STATE OF NORTH CAROLINA
DEPARTMENT OF TRANSPORTATION

June 14, 2019

Subject: **Response to NCDWR On Hold Letter dated May 9, 2019** for the extension and relocation of NC 84 from NC 16 to SR 1008 (Waxhaw-Indian Trail Road) in Union County. Federal Aid Project No. STP-1316(10), WBS 39019.1.1, Division 10, TIP No. U-3467.

Reference: 404/401 Individual Permit Application dated February 21, 2019
NCDWR On Hold Letter dated May 9, 2019

PROJECT REFERENCE NO.		SHEET NO.
U-3467		4
RW SHEET NO.		HYDRAULICS ENGINEER
ROADWAY DESIGN ENGINEER		
INCOMPLETE PLANS DO NOT USE FOR R/W ACQUISITION		
DOCUMENT NOT CONSIDERED FINAL UNLESS ALL SIGNATURES COMPLETED

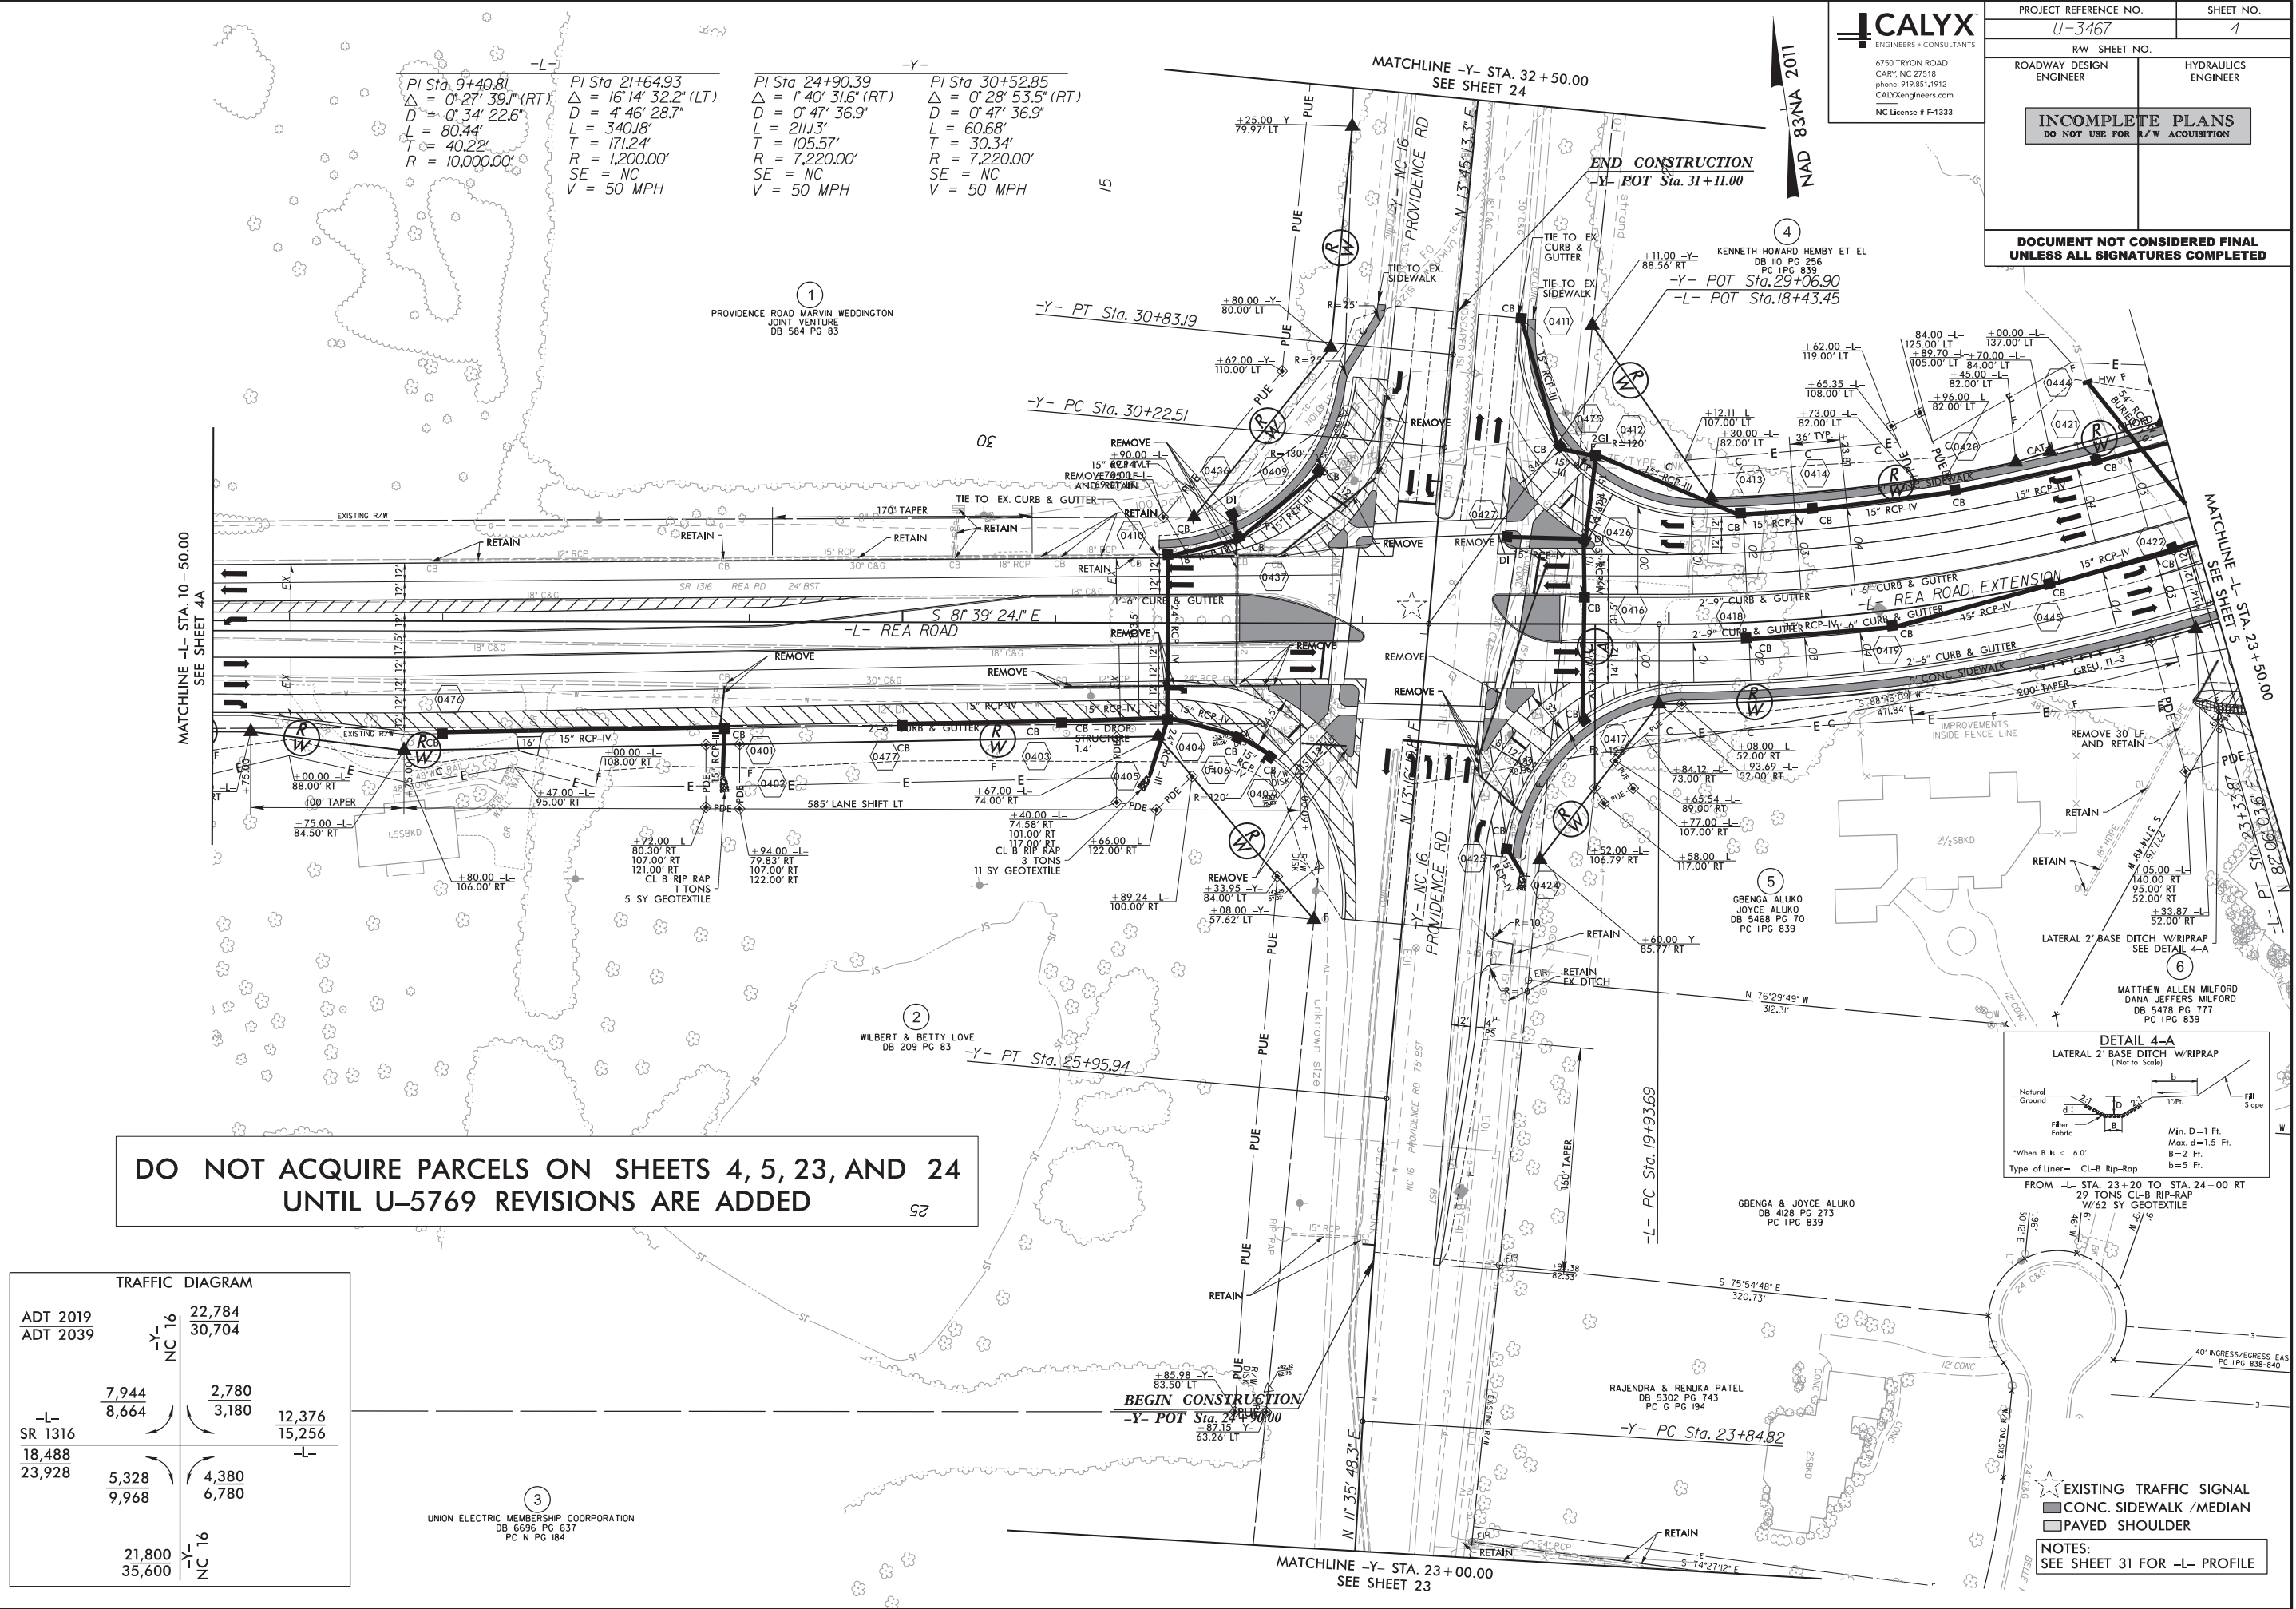
- Plan sheet 4: This swale would have to extend a significant distance downhill to get the appropriate depth and would extend well beyond the proposed ROW.

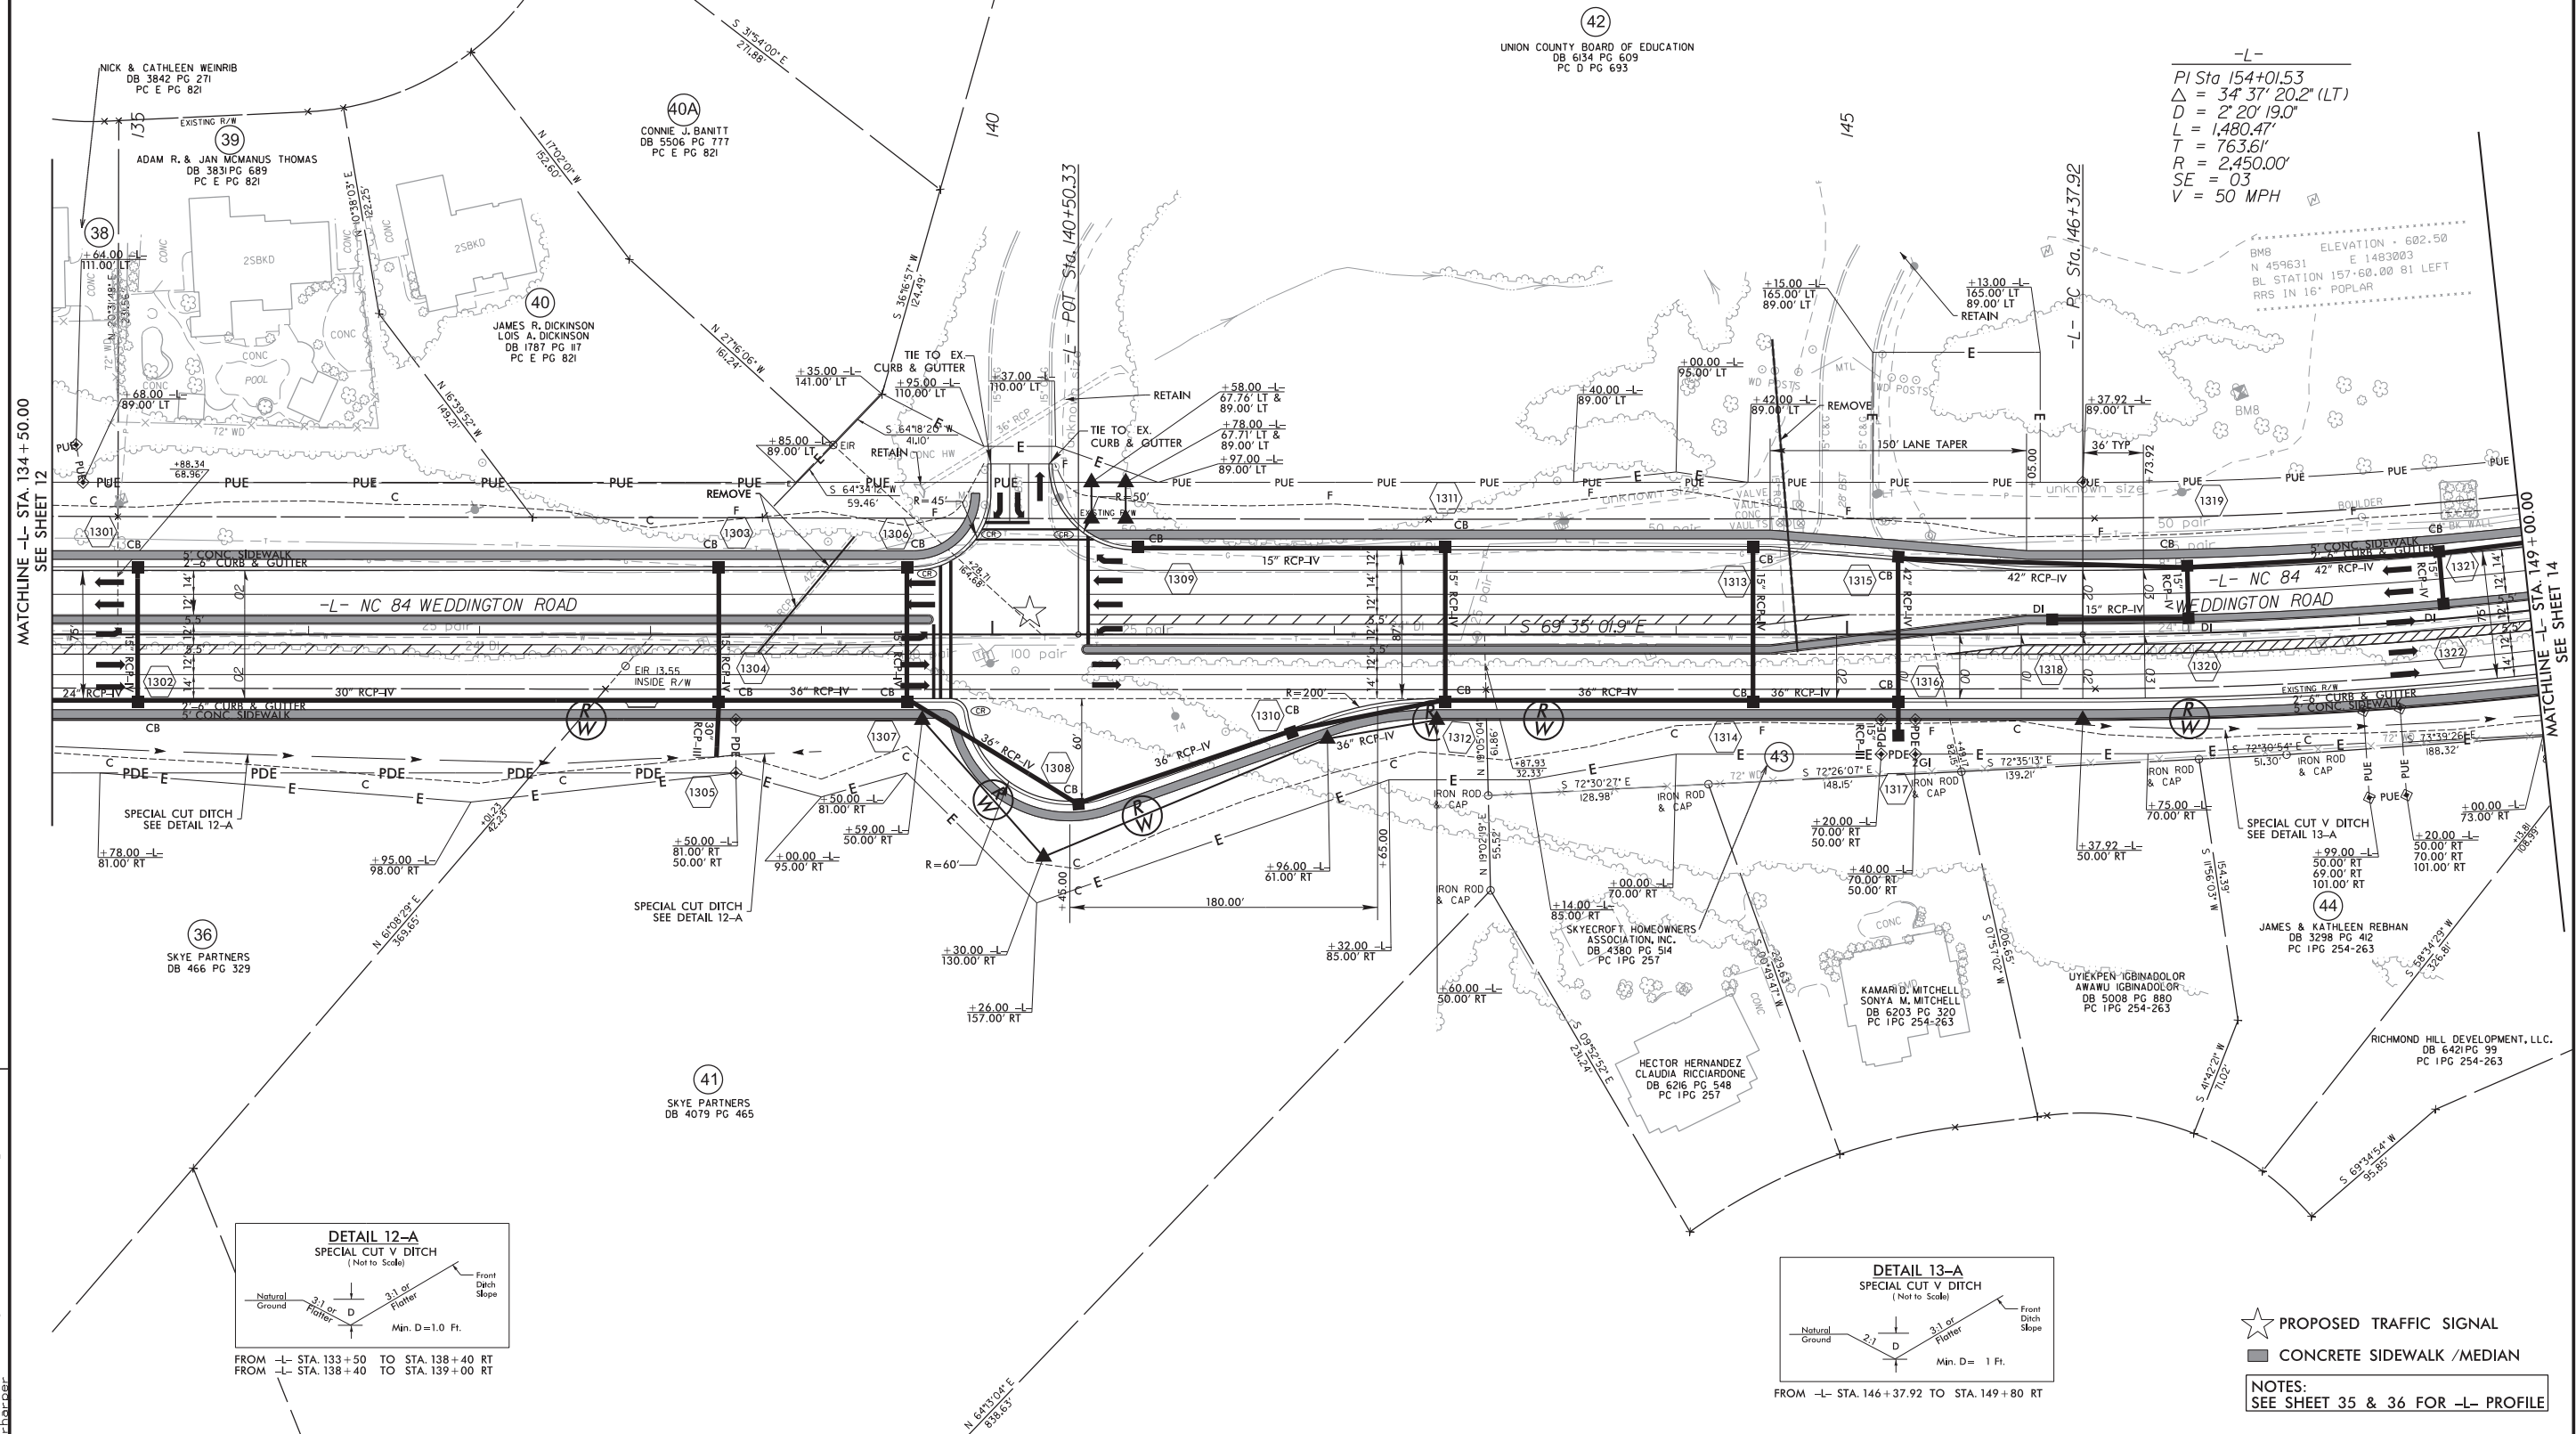
- Plan sheet 14, north and south side: This area has steep slopes leading down to Culvert Branch. The proposed ditch from -L- Sta. 159+85 to Sta. 161+46 Rt. has a 3.6% slope and a high velocity. Installing a swale on either side of the road in this location would require an extensive cut to flatten out the ditch to meet swale criteria. Additionally, the swales would extend past ROW.
